From: Mark Warwick
Sent: 24 May 2018 11:32
To: Simon Davis
Cc: Planning.Responses
Subject: RE: 3 The Orchard, Aldwick - AW/55/18/HH

From: Simon Davis
Sent: 23 May 2018 17:54
To: Mark Warwick
Subject: FW: 3 The Orchard, Aldwick - AW/55/18/HH

Drawing Title:
Tree Protection Plan

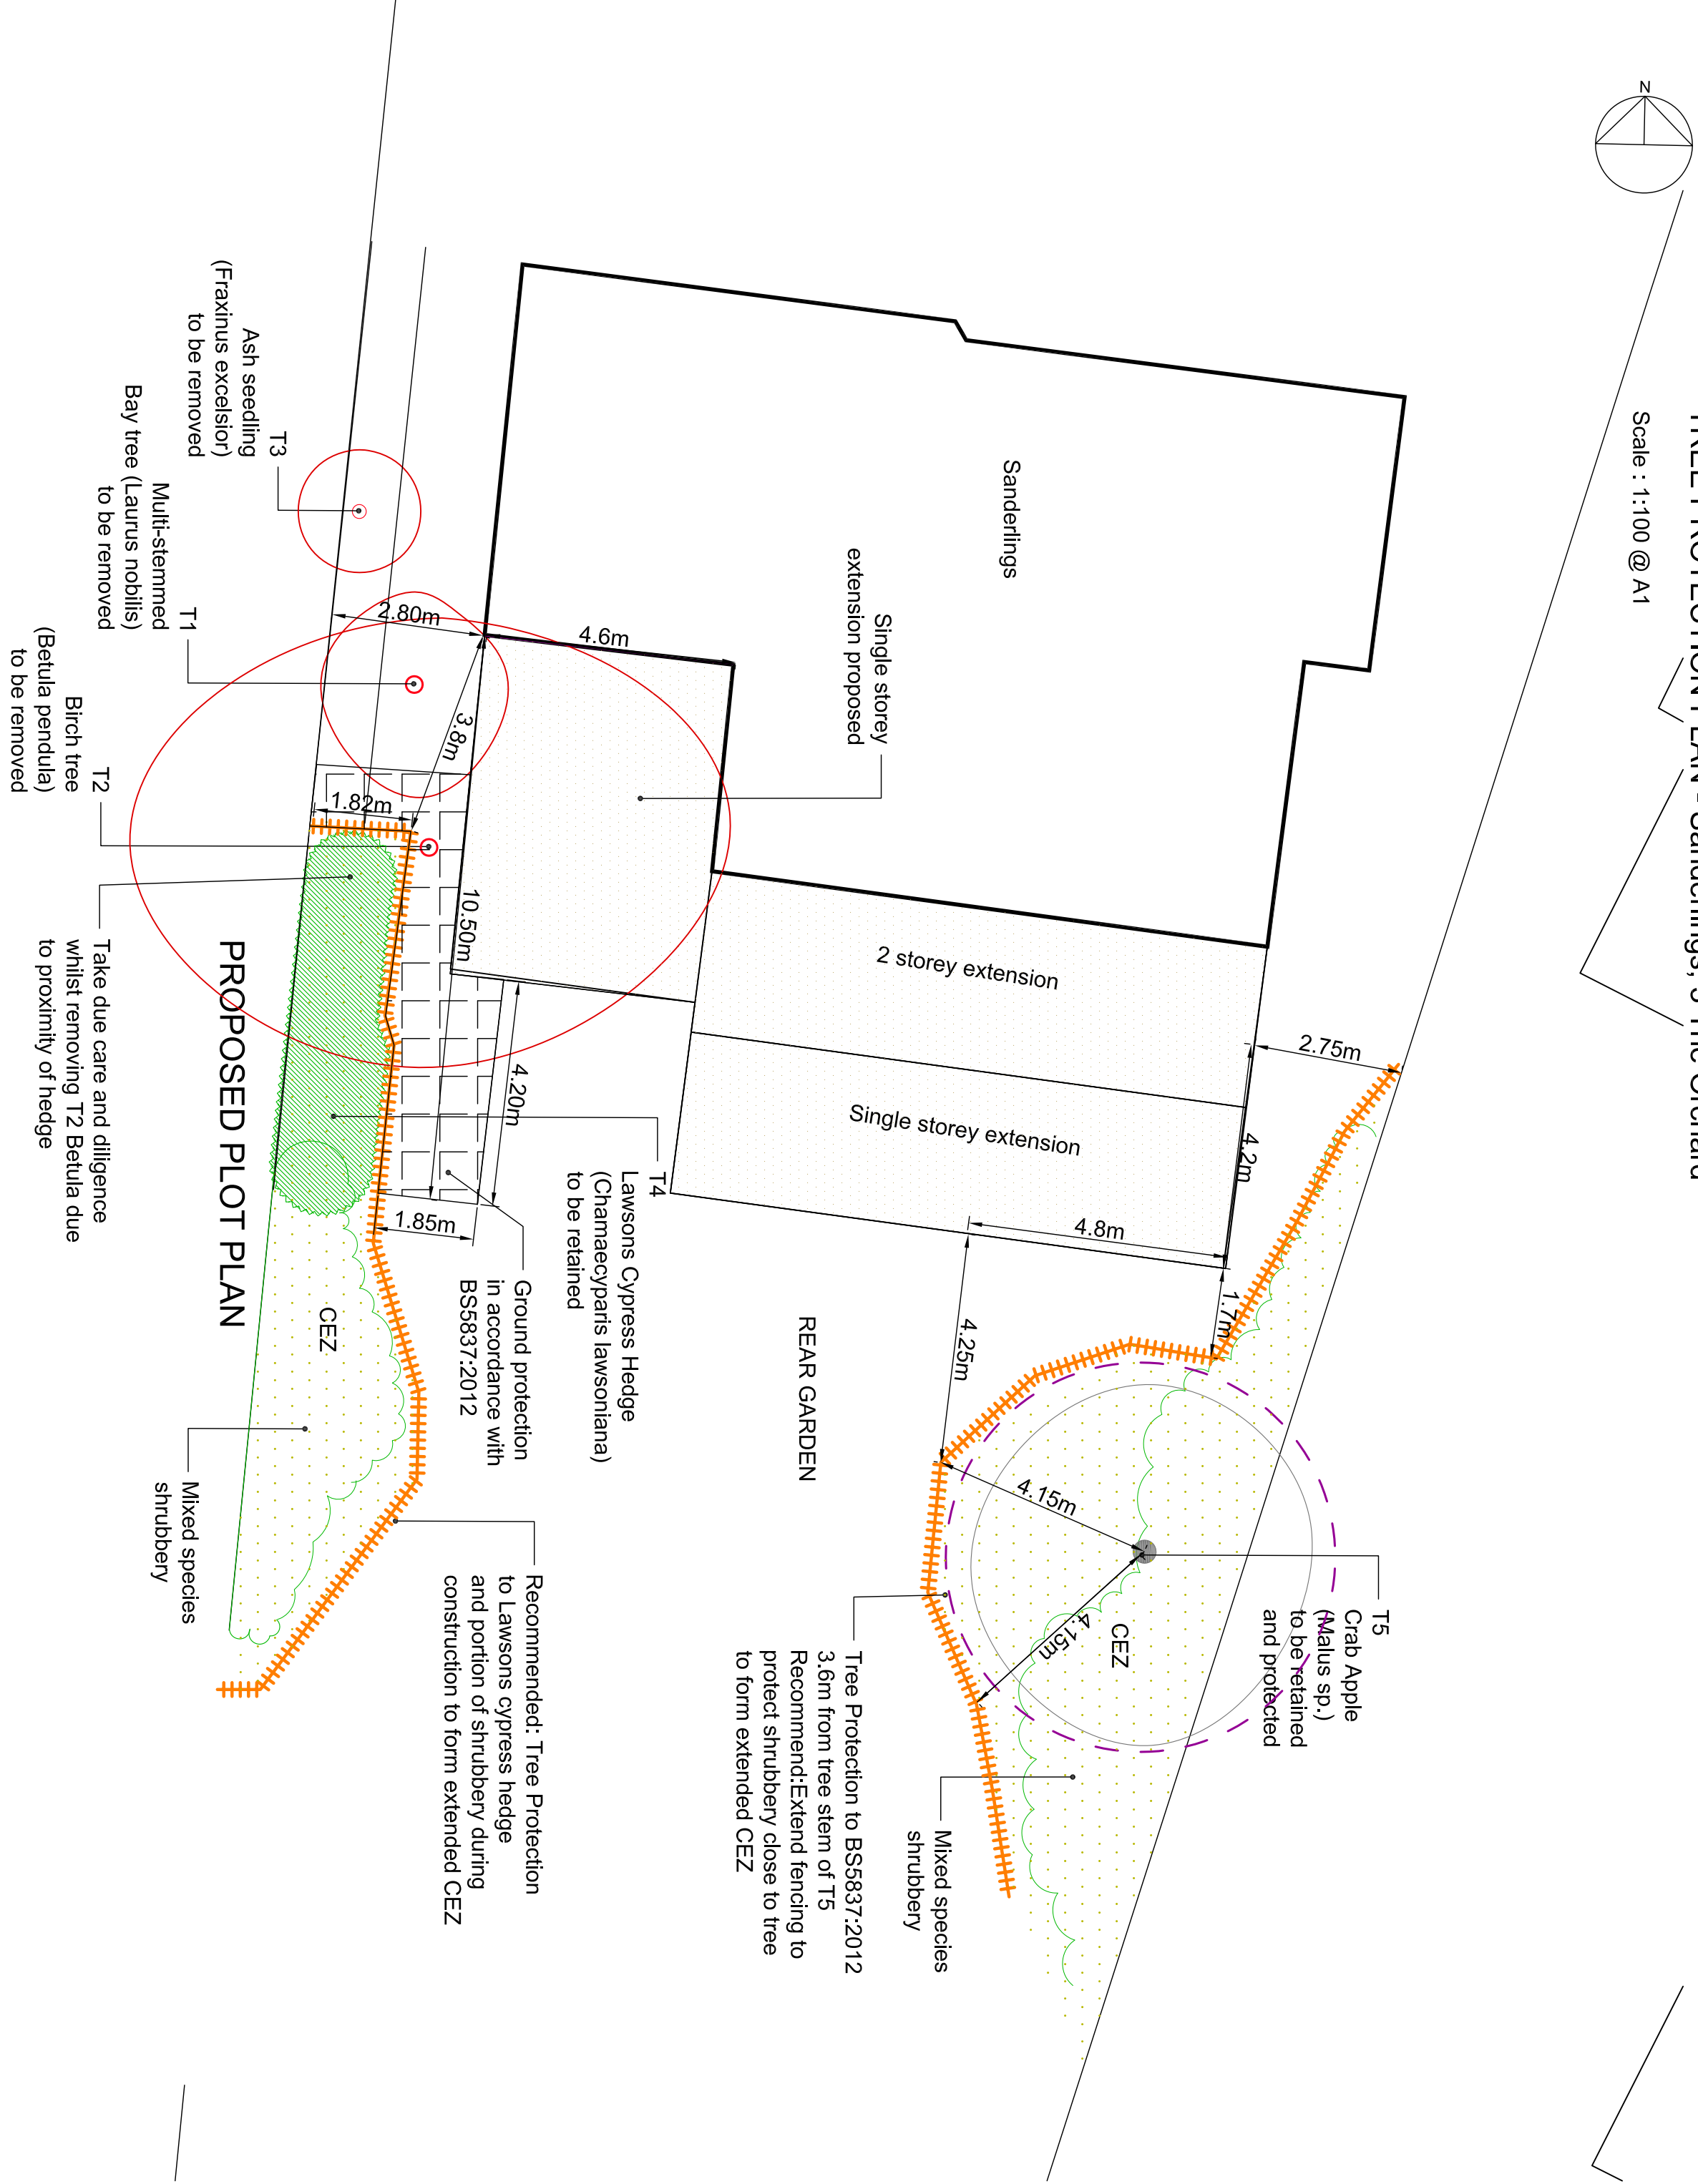
I refer to your email below and the attached revised Tree Protection Plan.

The amendments I sought as described in my email to you 14th May 2018, have now been included and to my satisfaction. I am therefore happy to recommend approval for this proposal, subject to the following condition being applied:

*Before the site is occupied or any machinery is introduced to the site or demolition work or construction work or alterations to existing ground levels occurs a **PRE-COMMENCEMENT Site Meeting** is to take place between the Arun DC Tree Officer and the Arboricultural Expert representing the site owners – at this meeting all protective fencing will be inspected along with ground protection measures – they will be assessed to verify that they are 'Fit for Purpose' as required under British Standard 5837 and have been erected and positioned exactly as shown on the **Tree Protection Plan (Dwg.No. 1035-5400, Date: 27th April 2018)**.*
